Question No.	Issue/Question	DCiC Response
1.1	<p>"Guillotine" provisions Articles 15(6), 19(11), 20(7), 22(6) Issue Specific Hearing 2 Issues and Questions (ISH2 I&Q) [PD-010] Q41 Applicant response [REP3-014] [REP3-026] DCiC response [REP3-027] EA response [REP3-034]</p>	<p>To date DCiC has not had any further discussions on this.</p> <p>On most articles the notice period negates the concern over the guillotine period. However, in response to the ExA Second Written Questions for Hearing 2 (Q41), DCiC identified it was not comfortable with Article 20 Discharge of Water, and questioned whether a notice period of 12 weeks (similar to Article 19) could be applied?</p>

<p>Applicant response [REP1-004] [REP2-020] DCC response [REP1-033] DCiC response [REP1-034] ISH2 I&Q [PD-010] Q68 Applicant [REP3-026]</p>	<p>February.</p> <p>b) There are questions concerning the appropriate use of stopping-up order. For example, do you need to stop-up highway rights for a footway/cycle way across the new A38 alignment, because the section in question is still in Highway or Highway verge? This needs a discussion with the applicant to understand why this approach has been taken.</p> <p>c) For the Appli

Drawing Number	Drawing Title	Revision
HE514503-ACM-ELS- A38_JN_J2_ZZ-DR-AB-0056	TPO LOSS MARKEATON JUNCTION	P01.3

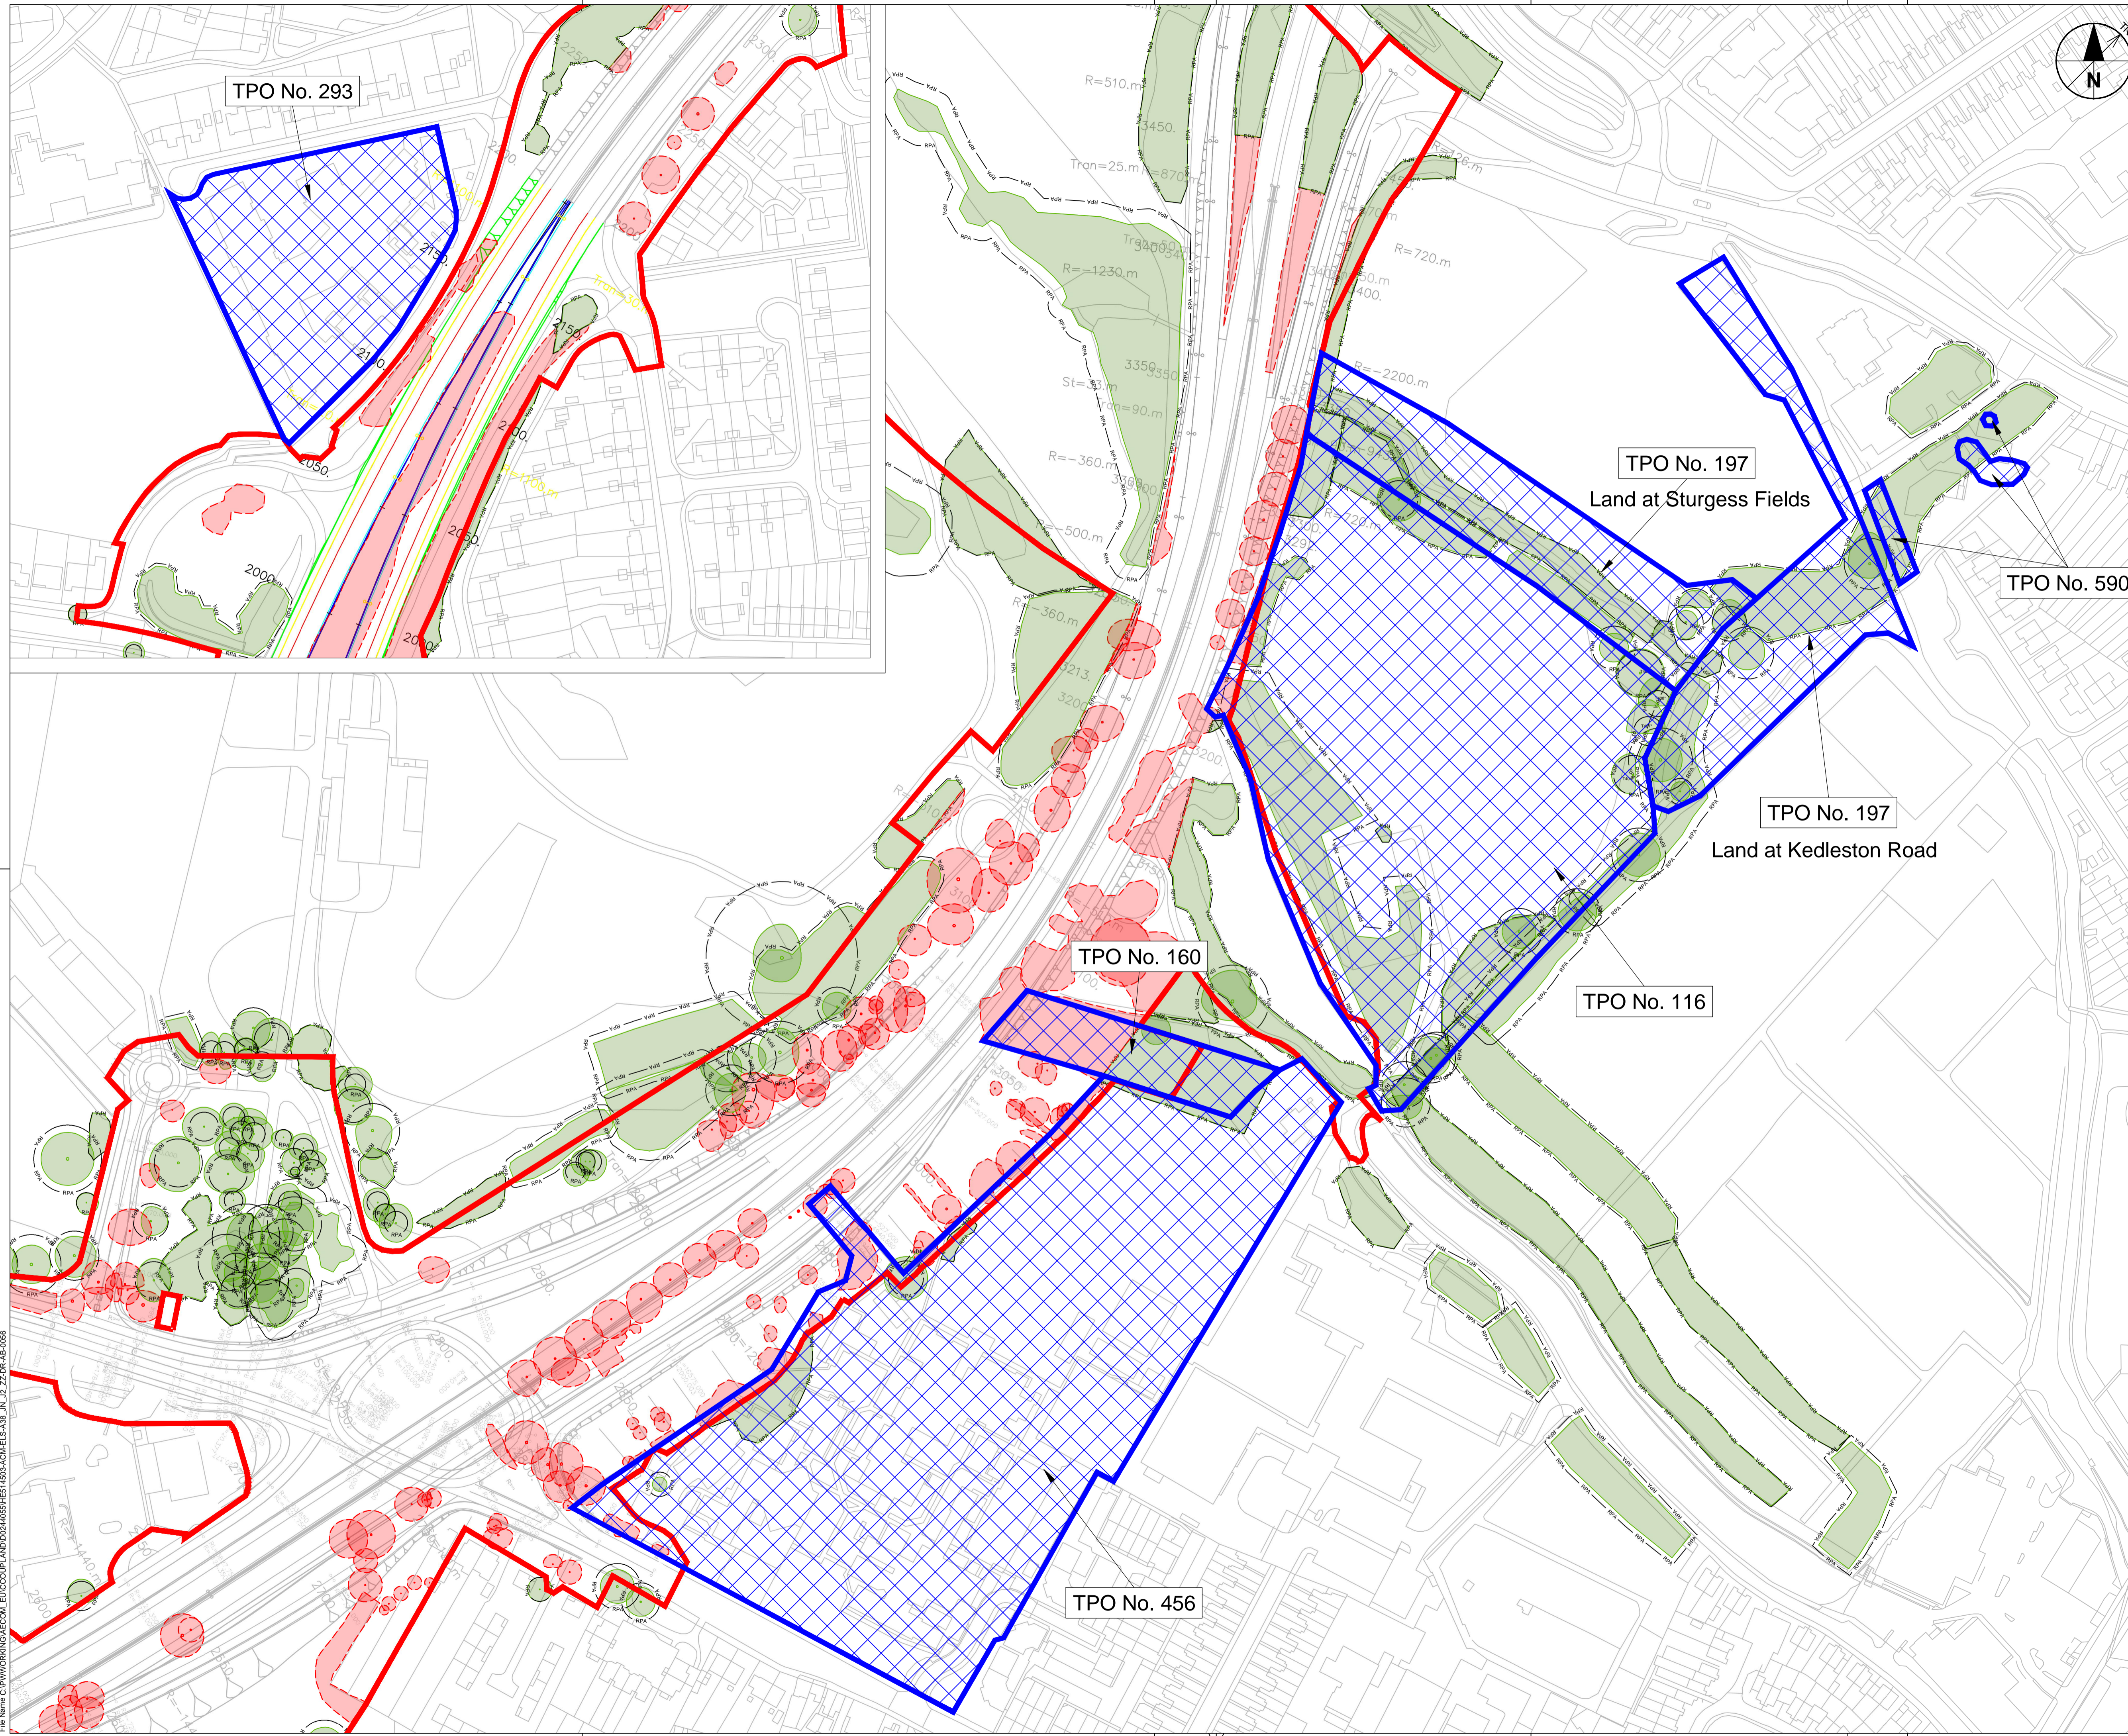
18			Area.
15	590	Woodland: W1, Group: G1 and Tree: T1	None
Sheet 17 And 18	160	Woodland: W1	West part of group proposed to be removed.
Sheet 17 And 18	456	Area: A1	Incursion into the west part of the TPO
Sheet 20	293	Area: A1	None

<ul style="list-style-type: none"> If permitted tree removals must comply with the tree protection measures as per Appendix E. A final Tree Protection Plan (TPP) and Arboricultural Method Statement (AMS) would need to be approved and must show the actual alignment of the Construction Exclusion Zone. The AMS must be compliant with 6.2 of the AIA with the addition of arboricultural monitoring and reporting at key events. It is important that the language of tree protection is changed from 'should' to 'will be' and 'must' unless an amendment is agreed by the project arboriculturalist.

Figure 1: T358 Root Protection Area (RPA) Impacts – shows existing and proposed indicative location of footbridge, plus Scheme features (carriageway, utilities diversions and highway drainage works)

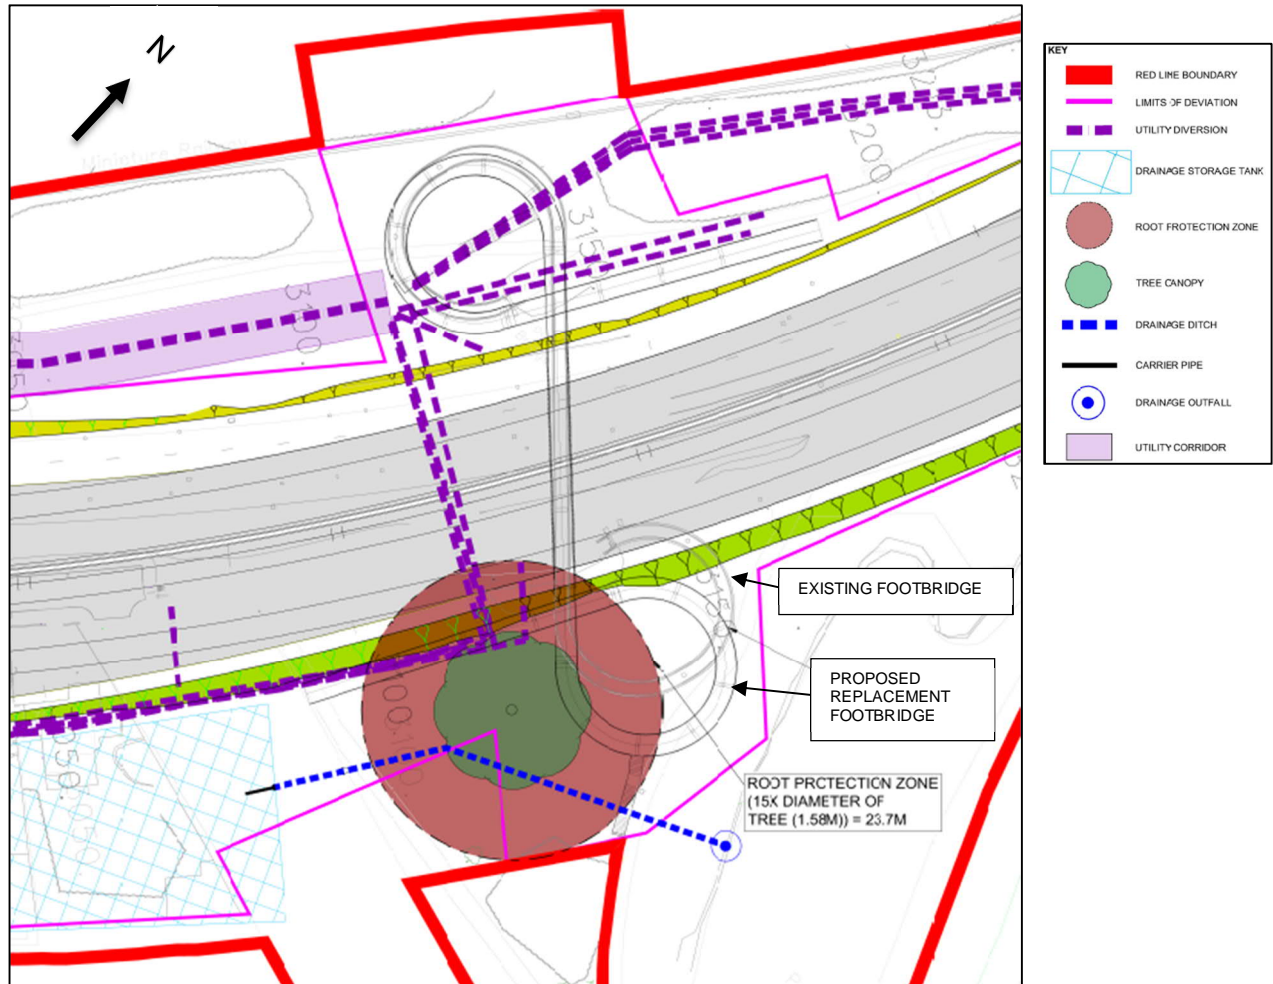
- Numerous trees proposed to be removed have accrued sufficient amenity value to justify inclusion within a TPO. Of particular importance is T356 (Oak). This has a stem diameter recorded as 1575mm which equates to a girth of 495cm. According to Ancient and other veteran trees: further guidance and management Fig 1.3 Chart of girth in relation to age and developmental classification of trees the tree (T358) is categorized as veteran/notable.

Buffer Zones around a veteran tree should be at least 15 times the stem diameter. The buffer zone around T358 should be 23.6m. RPA's within the report indicates the correct buffer zone. The proposed route means that the RPA is

<p>compromised. T358 is not recorded on the Ancient Tree Inventory. T358 is proposed to be removed. This will lead to a long term negative impact on an irreplaceable habitat.</p> <p>Numerous trees within Markeaton Park are recorded in the Ancient Tree Inventory. The removal of trees will result in a loss of public amenity and wildlife habitat/foraging provision. It is noted that details of numbers of trees to be planted has not been provided.</p> <p>DCiC would expect an assessment of tree loss compared to proposed trees planting and would expect to see a net gain of tree infrastructure.</p> <p>Trees planted in mitigation will take many years to replicate the amenity/wildlife provision that the existing trees provide. It was not thought expedient to make trees owned and managed by Derby City Council subject to a TPO.</p> <ul style="list-style-type: none">• RPA radius are not shown on the schedule. However referring to the plans I can confirm that veteran tree RPA's have been amended to follow guidance in Ancient and other veteran trees: further guidance and management of 15 x stem Ø as opposed to the BS5837 of 12 x stem Ø.• T280 RPA should be 31.5m.• RPA's are shown as circles irrespective of existing constraints.• Annoyingly '7' is shown as a '□' on the plans.
